1no. new dwelling (re-submission of approved application reference EP/105/16/PL).
Seahaven (Land West of Ash Hollow) Seafield Road East Preston

Thank you for your internet comments made on 25th July 2019 which has been recorded as **'an objection'** with the comments as follows:

This council's Planning & Licensing Committee considered this Application at its meeting on Monday, 22nd July. The applicant and agent were invited to attend but were unable to do so.

Job Title	Seahaven, Seafeld Road, East Preston		
Client	Mr & Mrs D Guise		
Drawing Name	Elevations		
Drawing Status	Planning		
Drawn by	DF	Date	June 19
Checked by		Date	
Drawing Scale	1:100 at A1		
Drawing No	Status	Revision	
193008/	03

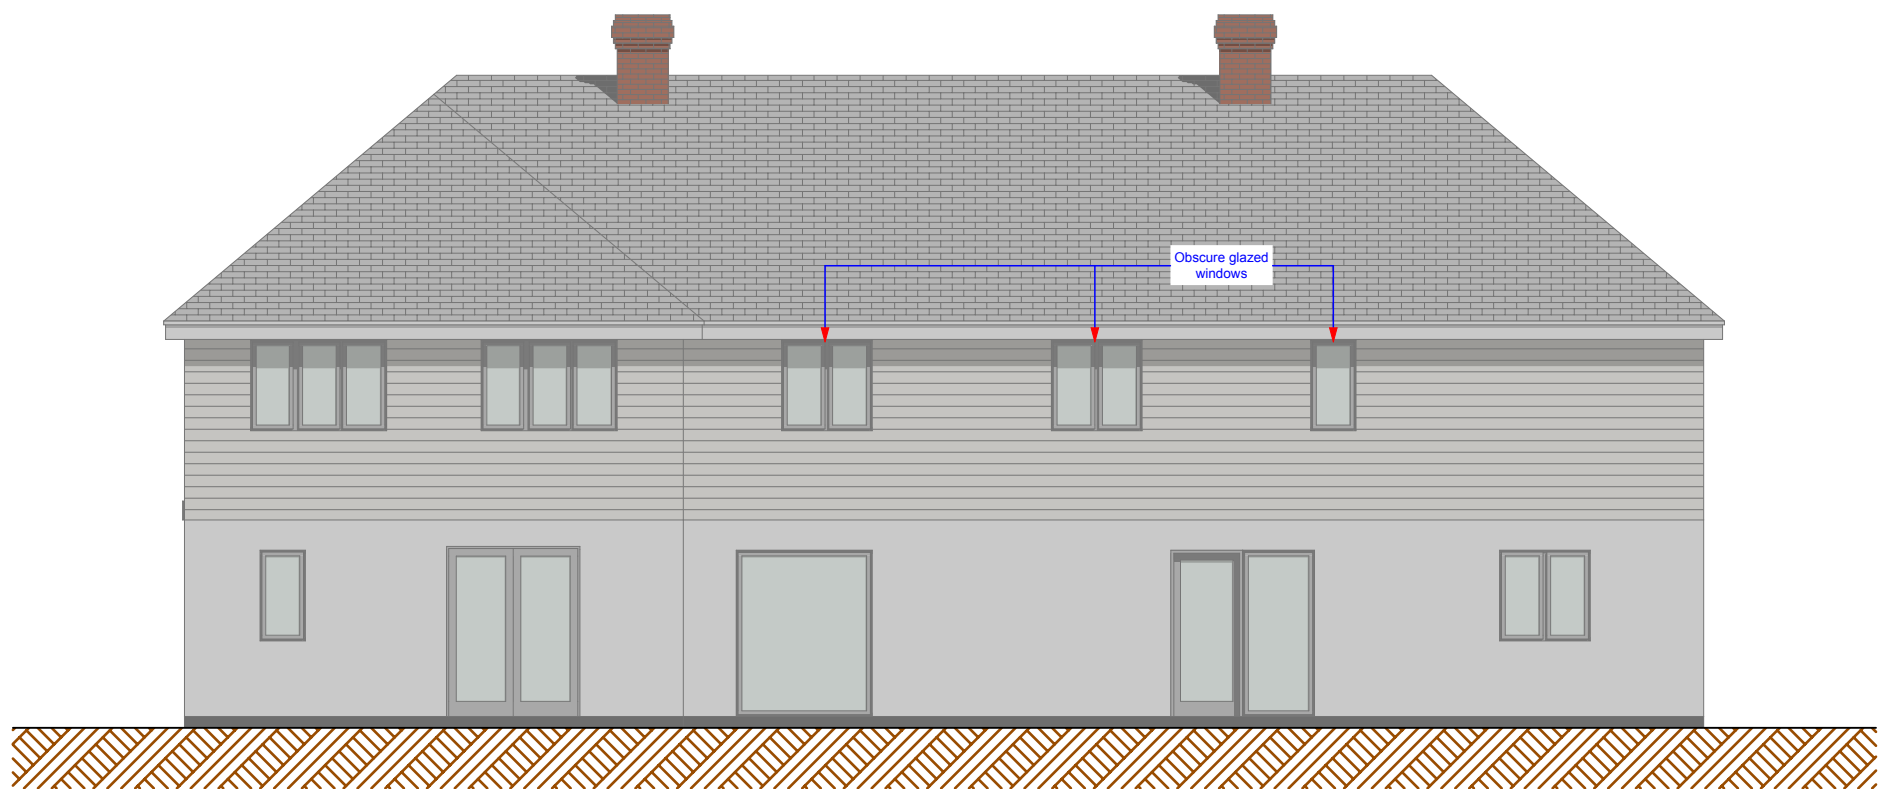
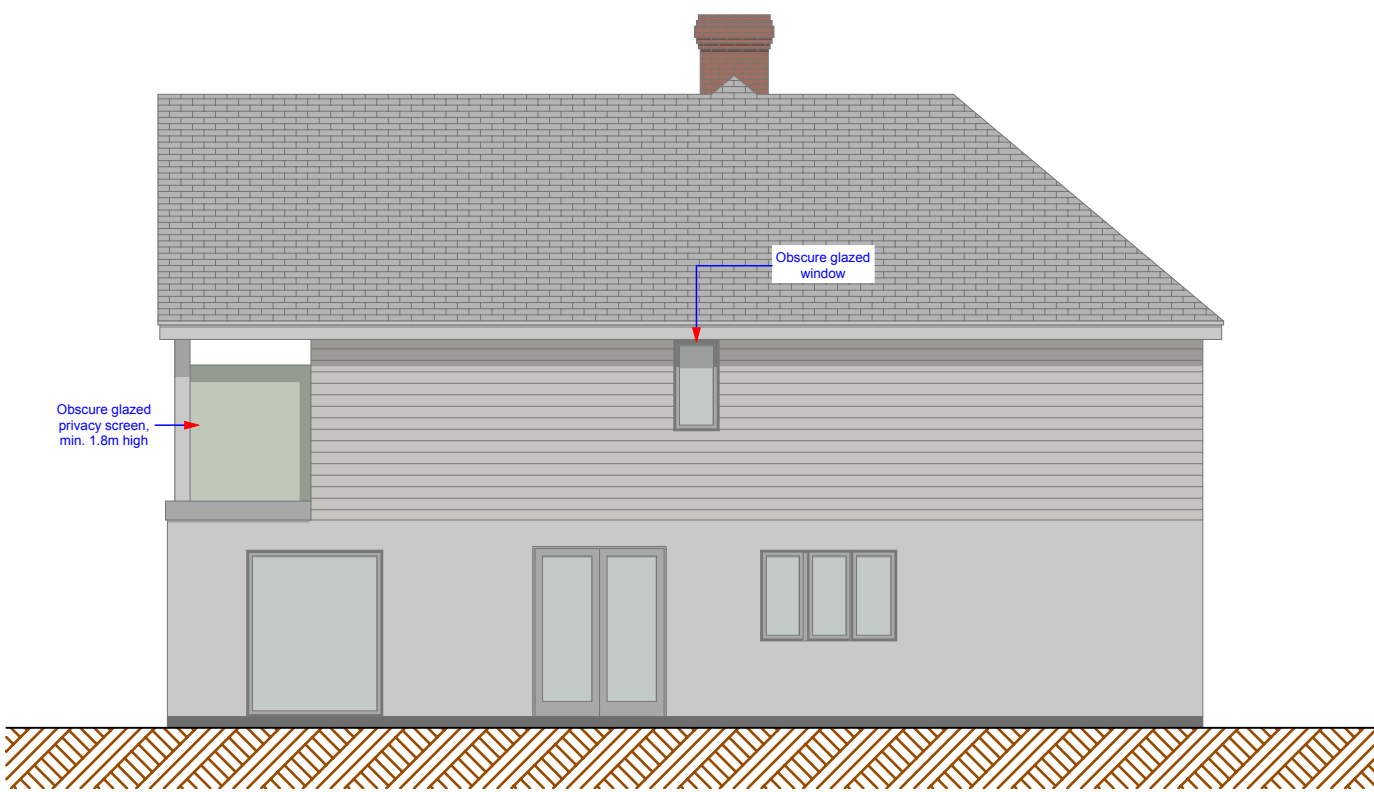
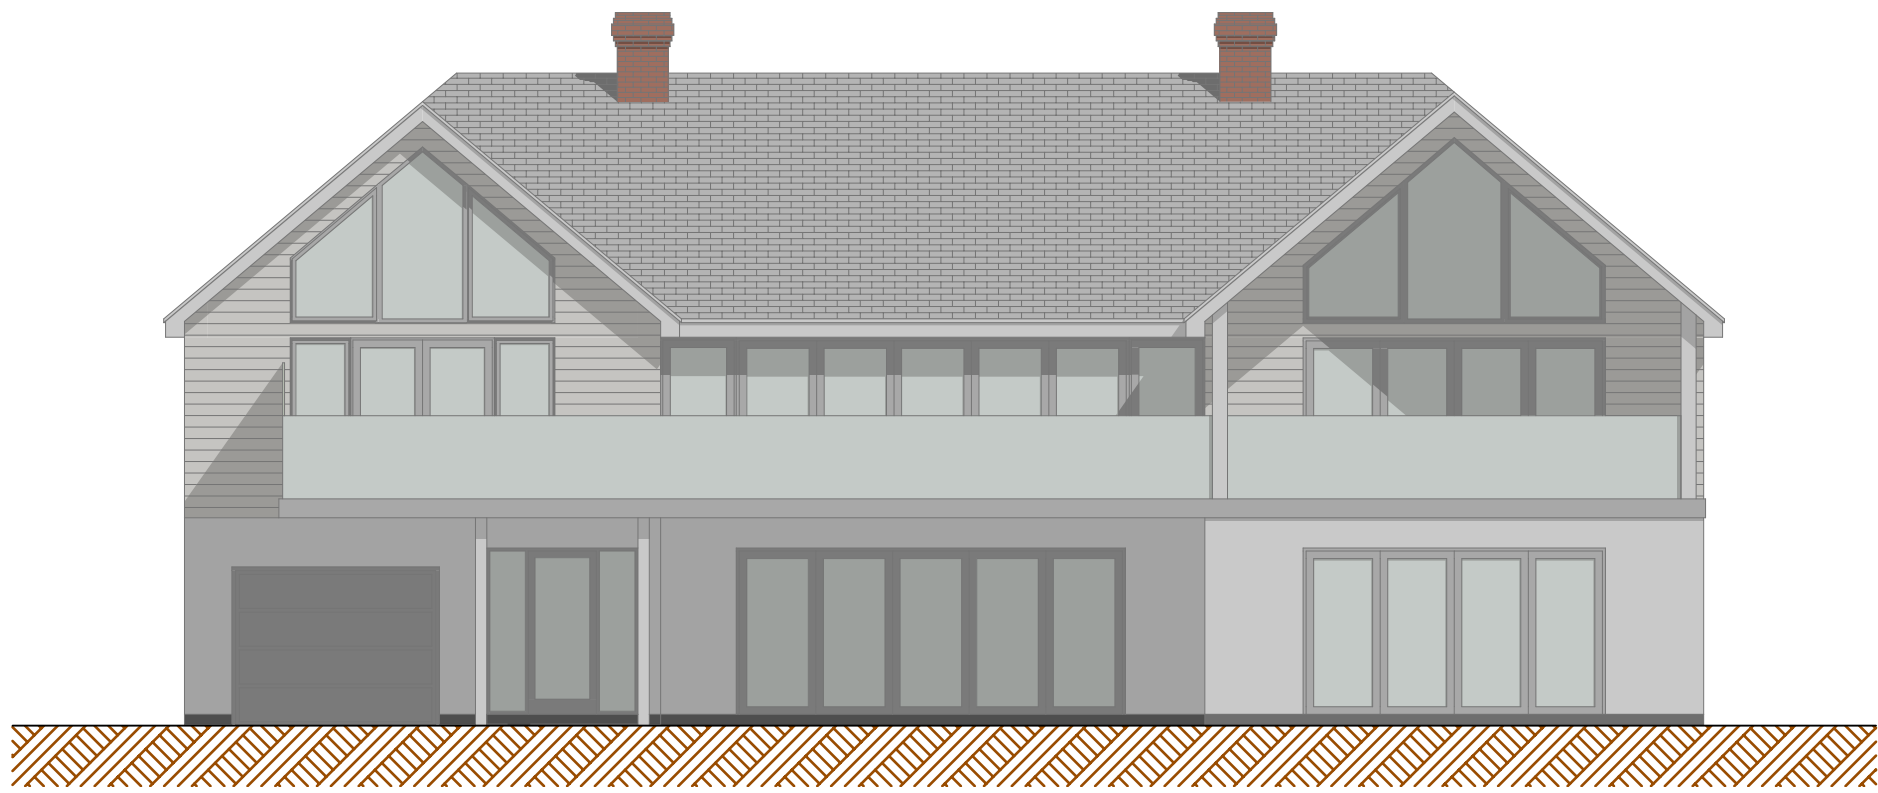
The committee agreed to object to this Application as possible overdevelopment of the plot and because the proposed materials did not harmonise with other long-standing properties within this Area of Special Character. The committee also felt the increased height of the proposed property over that already given Planning Permission would result in too tall a building, which may appear overbearing to neighbouring properties.
